Application No: FG/90/21/HH
Site Address: 1 Sea Drive Ferring BN12 5HD
Description of works: Erection of addition of second floor, part single, part two storey extension and wrap around terrace

Thank you for your internet representation made on 28th May 2021 which has been recorded as an objection with the comments as follows:

Project: Extension & Refurbishment	
for Chris Levett	
at 1 Sea Drive Ferring Worthing BN12 5HD	
Contact: Michael Austin R/BA E-mail: project@austinglebbon.co.uk Web: www.austinglebbon.co.uk Phone: 07958427610	
Dwg Ref: 2048 [PL] 06	Rev: - Date: May 2021

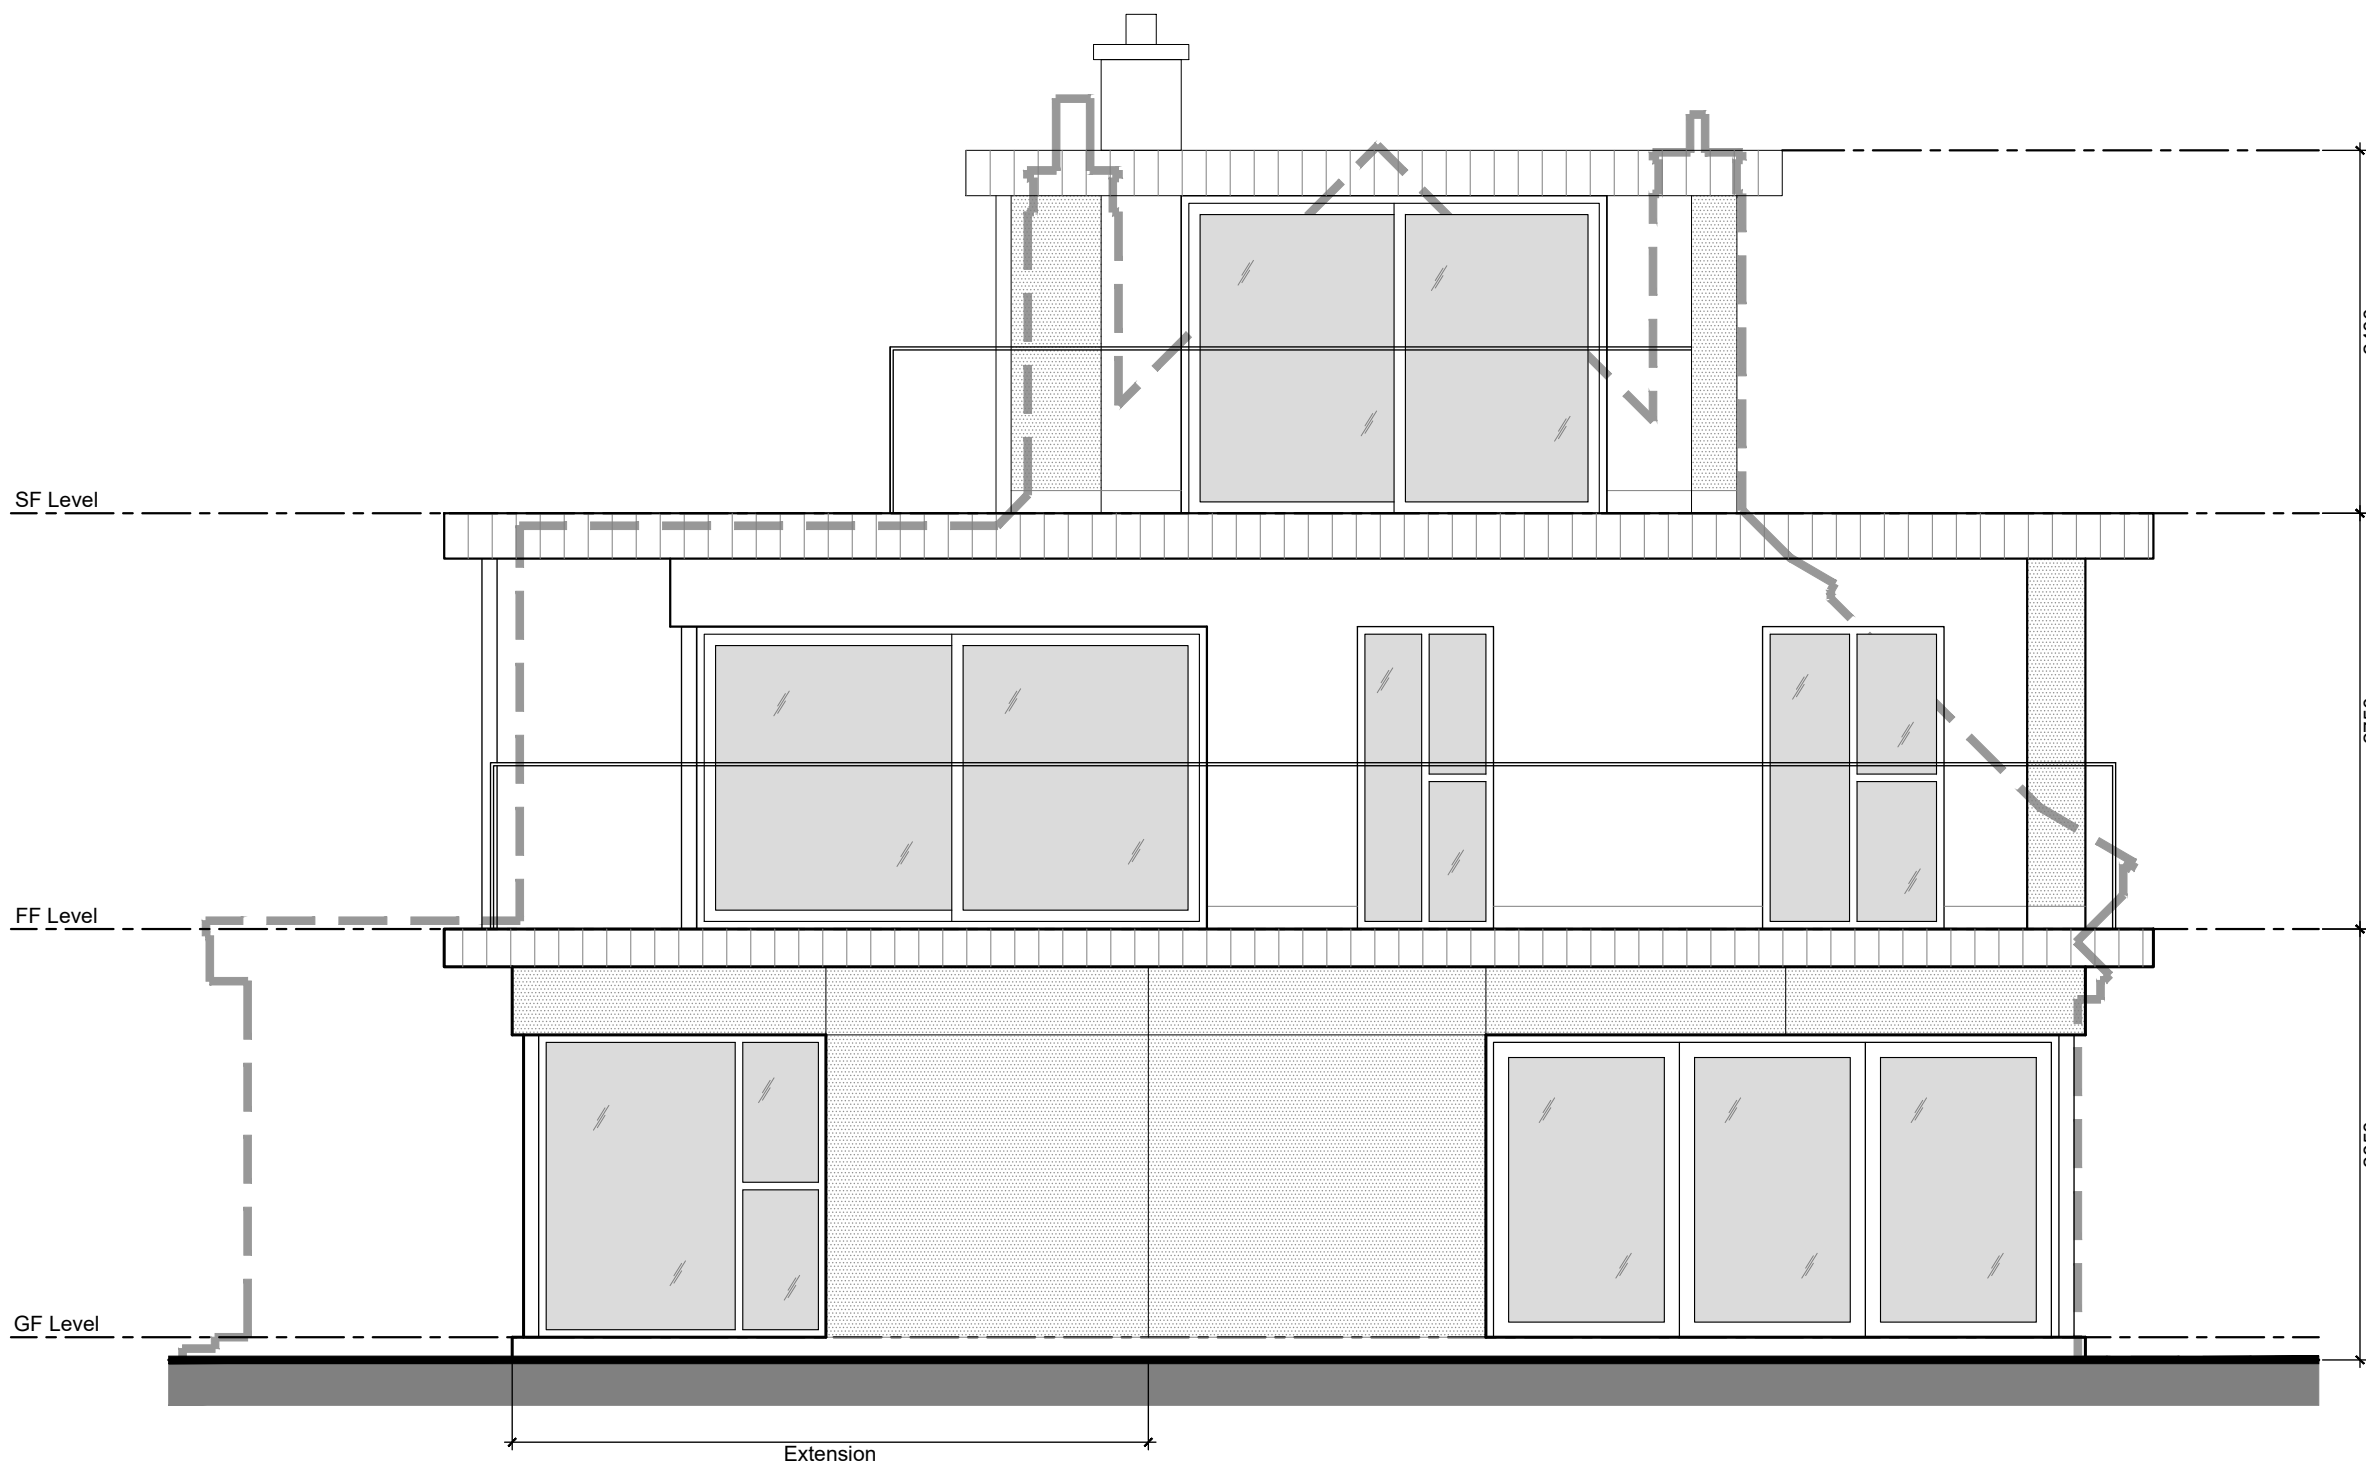
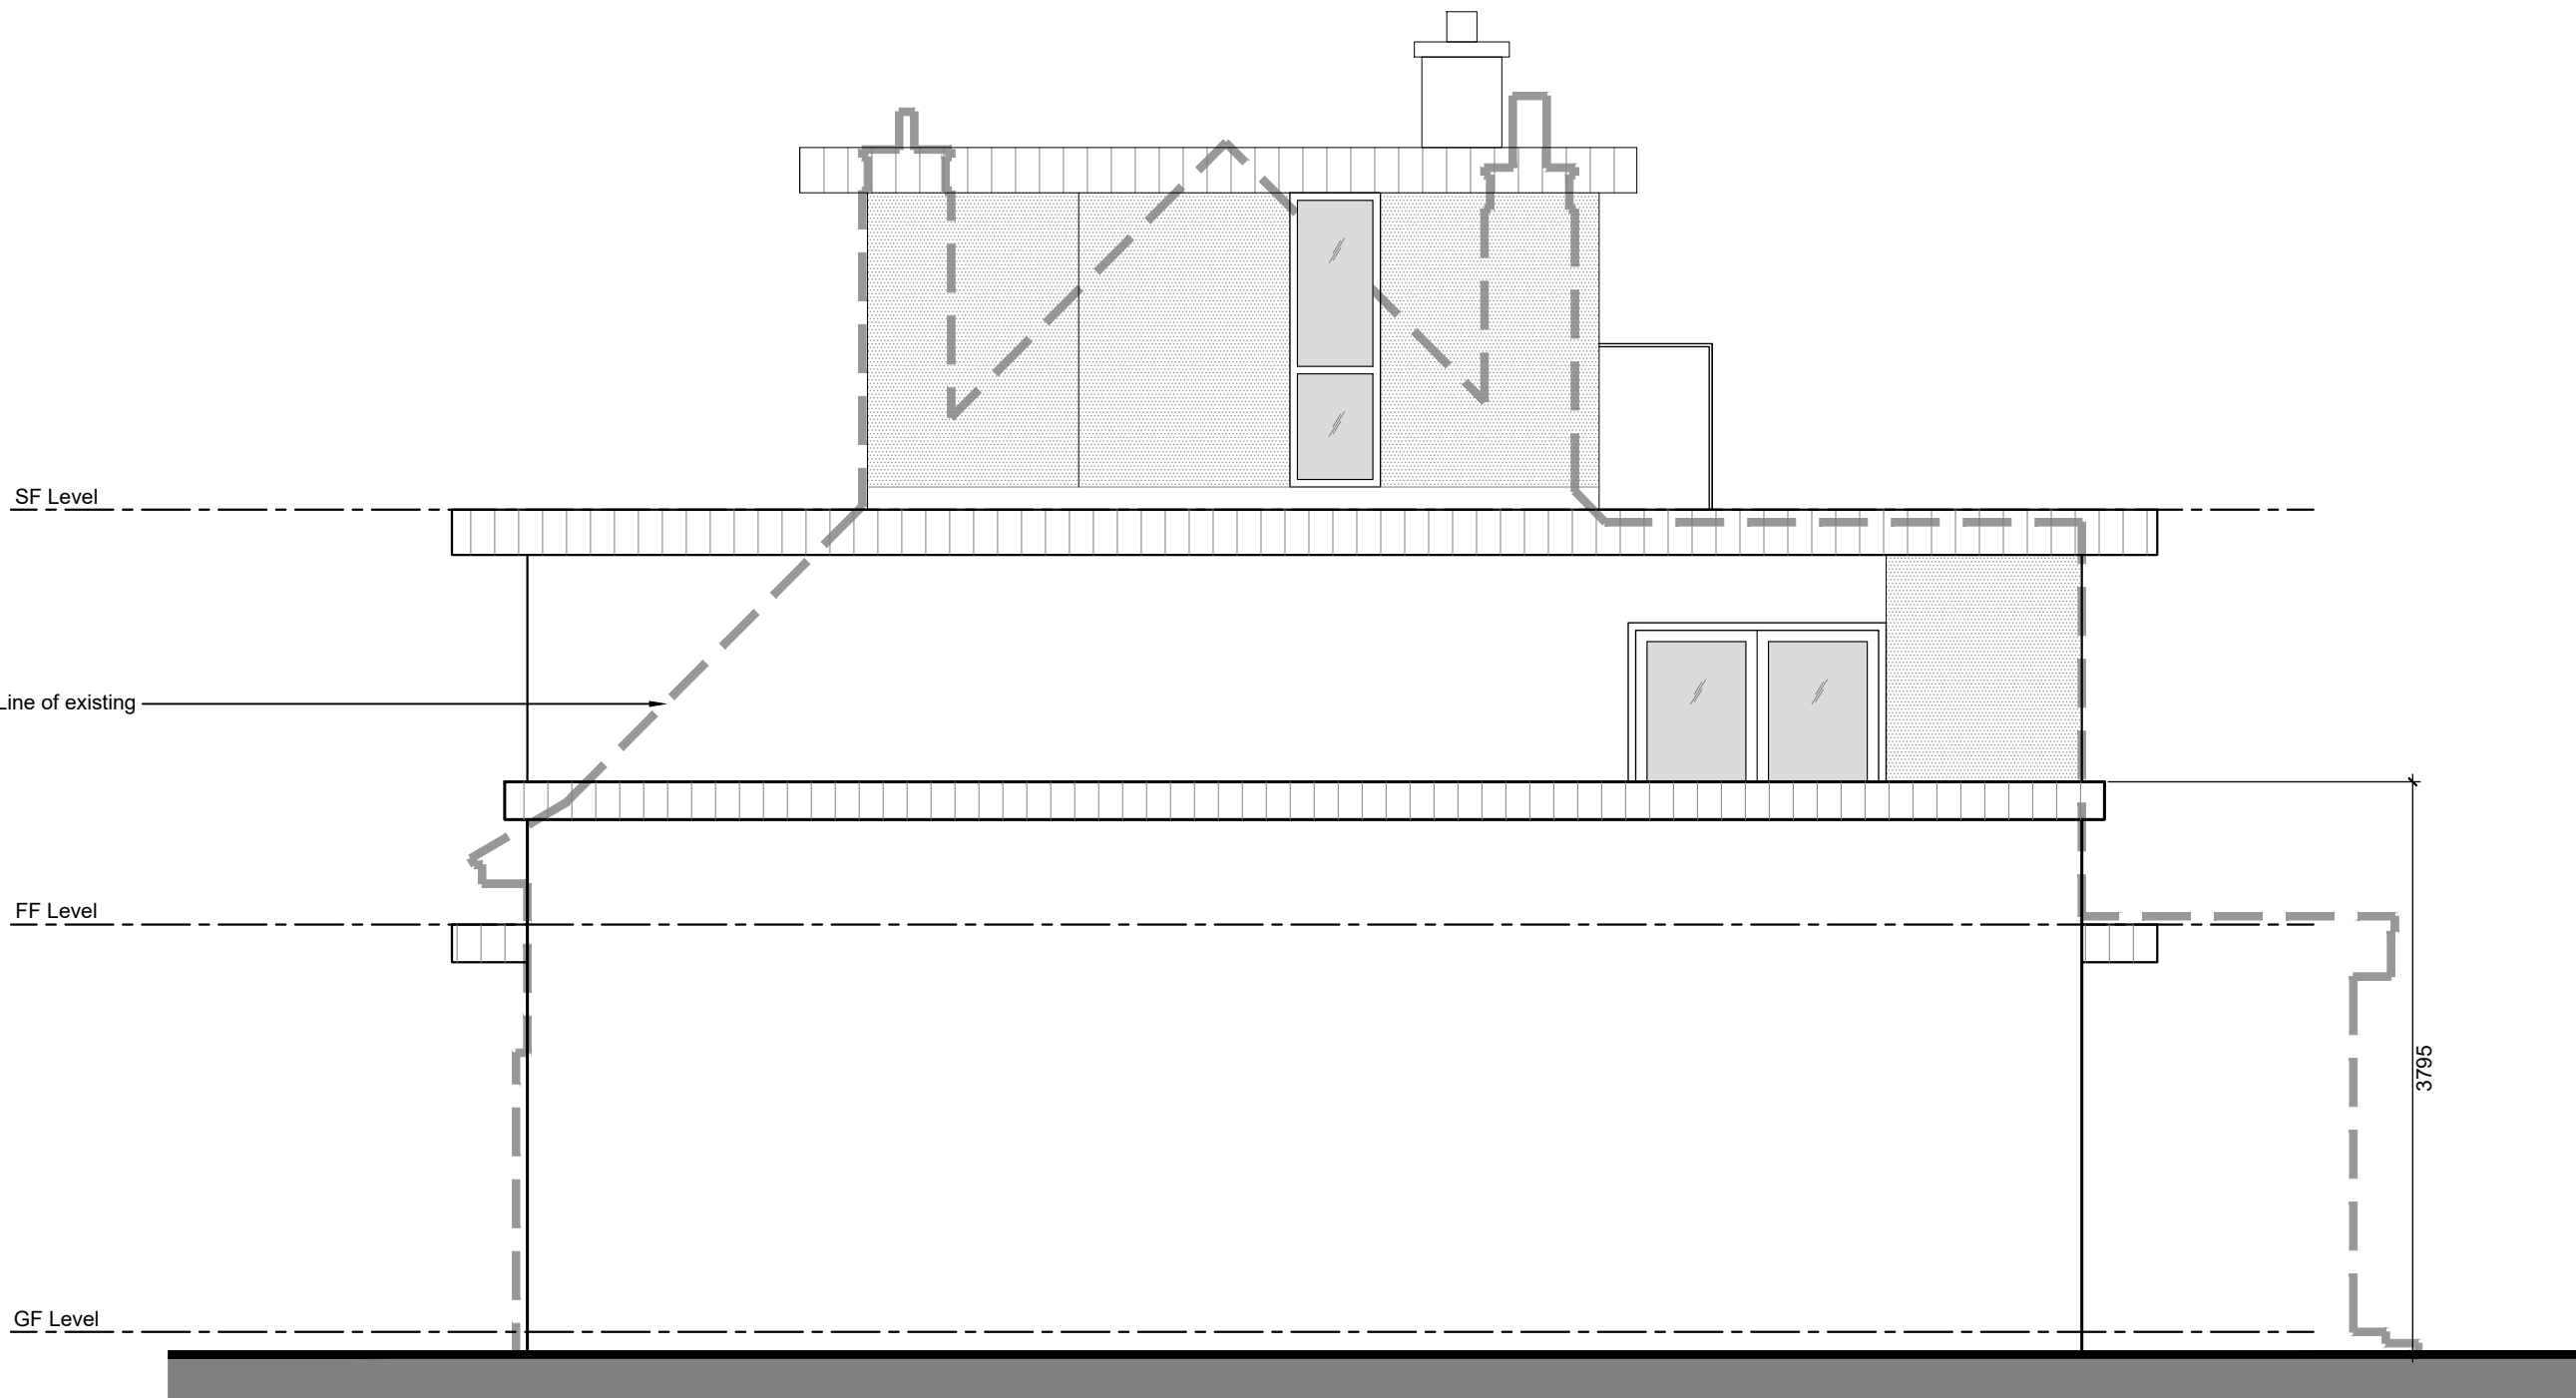
Overbearing because it dwarfs No. 2 Sea Drive and overlooking because its terraces its terraces and balconies give direct views in the back garden of that house.

Project: Extension & Refurbishment	
for Chris Levett	
at 1 Sea Drive Ferring Worthing BN12 5HD	
Contact: Michael Austin R/BA	
E-mail: project@austinlebbon.co.uk	
Web: www.austinlebbon.co.uk	
Phone: 07958427610	
Dwg Ref: 2048 [PL] 05	Rev: - Date: May 2021

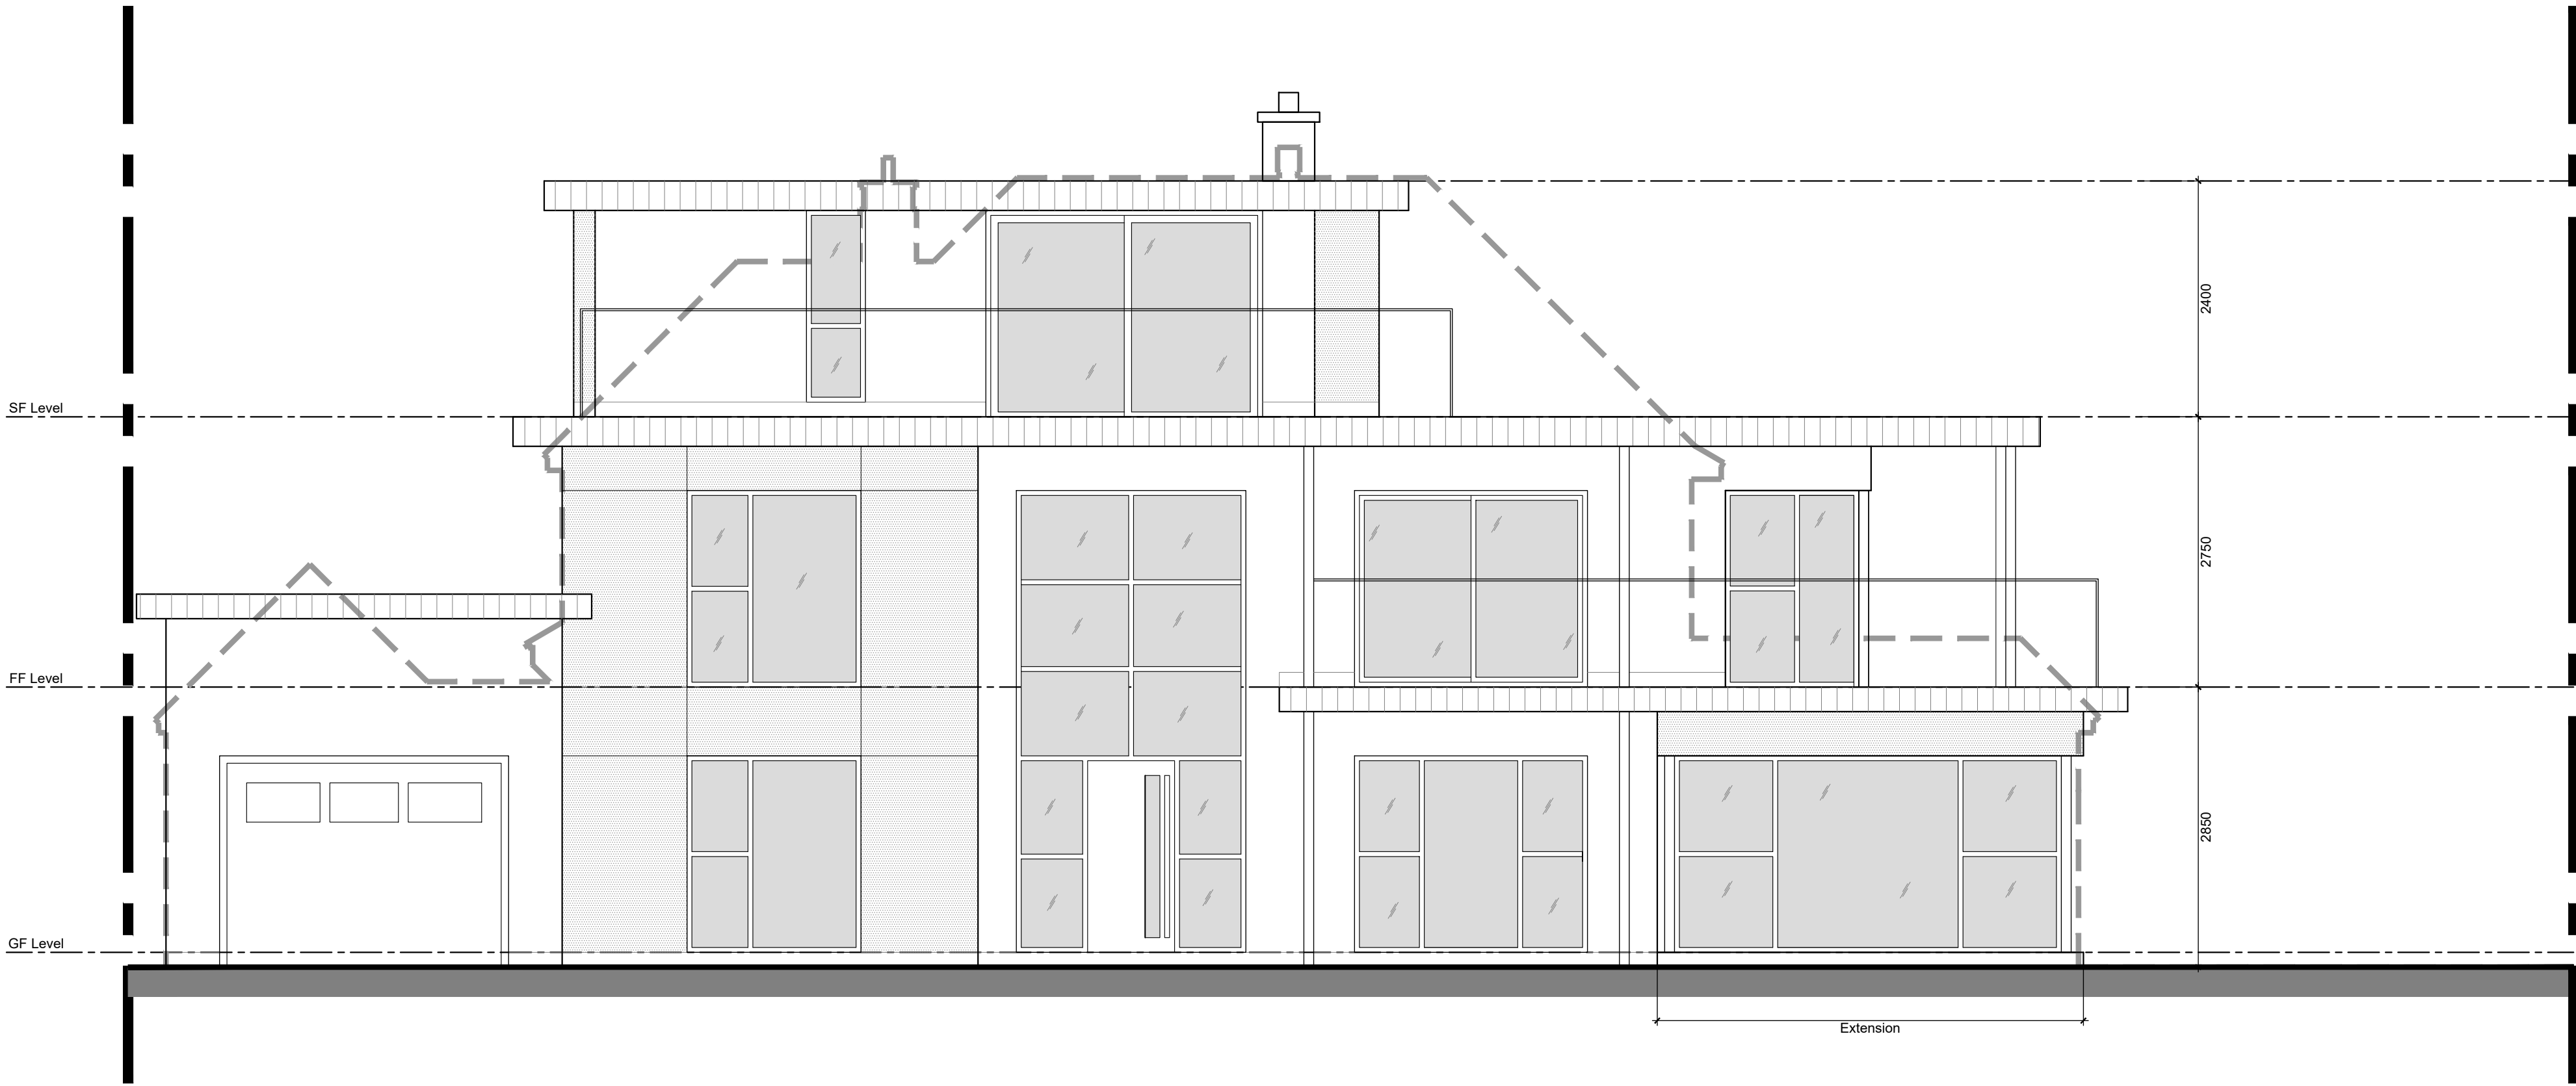
Unacceptable impact on street and locality because the third storey, with a flat roof, perched on top of the existing building, is incongruous in a key location.
